Response to Submissions SSD 7372 – Modification 2 - O'Connell Street Public School

On 17th July 2017, The Department of Planning and Environment (DPE) invited public authorities to provide comments on Modification 2 of SSD 7373 for the O'Connell Street Primary School.

In total four agency submissions were received. Neither City of Parramatta (Council), nor any of the agencies objected to the proposed photovoltaic panels located on the new hall. However objections were raised regarding the proposed extension of the plant platform and mechanical plant facilities located on Building B in terms of visual, heritage and noise impacts.

Figure10: North Elevation showing the Proposed location for the extension of the Plant Platform.

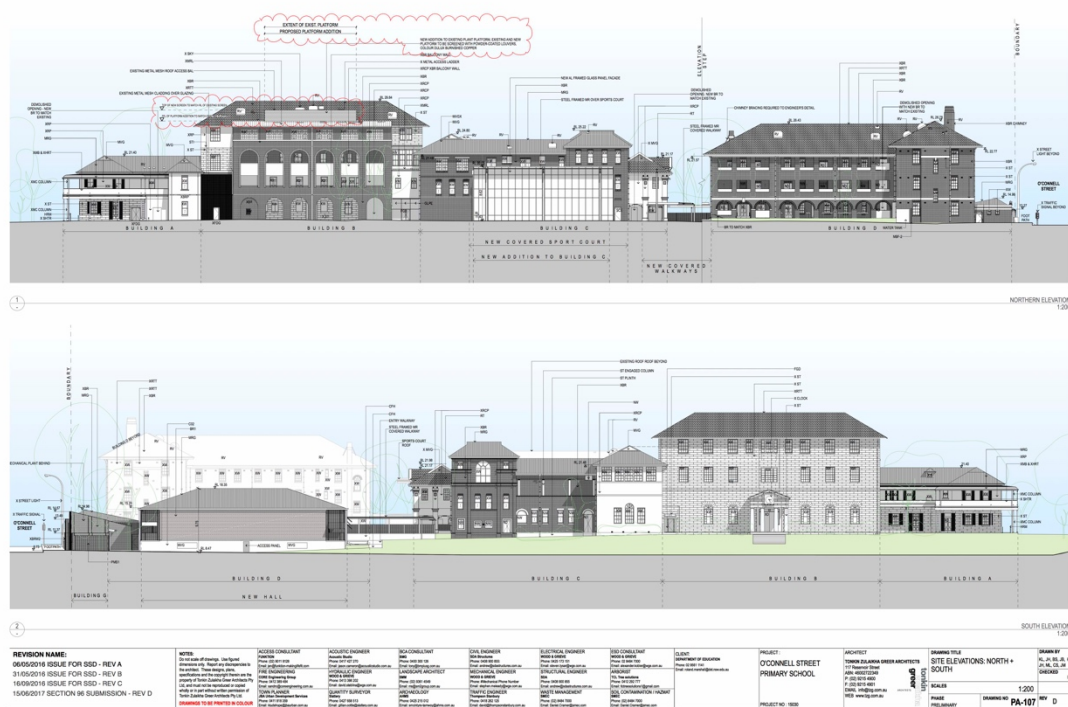
Both Council and OEH raised objection to the visual and heritage impact of the proposed extension to the platform and mechanical plant facilities.

Council notes that the enlarged footprint and width increases the bulk and therefore increases the visibility of the structure when viewed from the north, east and west.

OEH outlined that the proposal is not supported as there is a conflict with policy 21.1 of the 1994 Conservation Management Plan, which states that the addition to the main school building is of high heritage significance and the original exterior should be recovered by the removal of intrusive elements such as the mechanical service elements on the roof.

OEH recommended that further options be considered by the proponent with the aim of removing the mechanical services from the roof entirely and a revised proposal be prepared.

TGZ state that it is not possible to remove the plant platform from the roof entirely and its impact has been minimised by the following measures:

- The size of the extended roof platform has been kept to a minimum and detailed in a contemporary yet complementary manner to integrate with the existing platform. The impact of the extension has been minimised by designing it as a light, steel framed secondary element that is obviously contemporary, removable in the future, and respectful of the heritage significance of the place.

- The new powder coated louvre screens proposed will enclose the platform, unify the composition and ensure that the visual impact of the addition is reduced.

- The location of the extended mechanical plant platform ensures that impacts on significant fabric are minimized, sitting below the ridgeline and not prominent from most viewpoints, and screened entirely from the south, the key view, and the west.
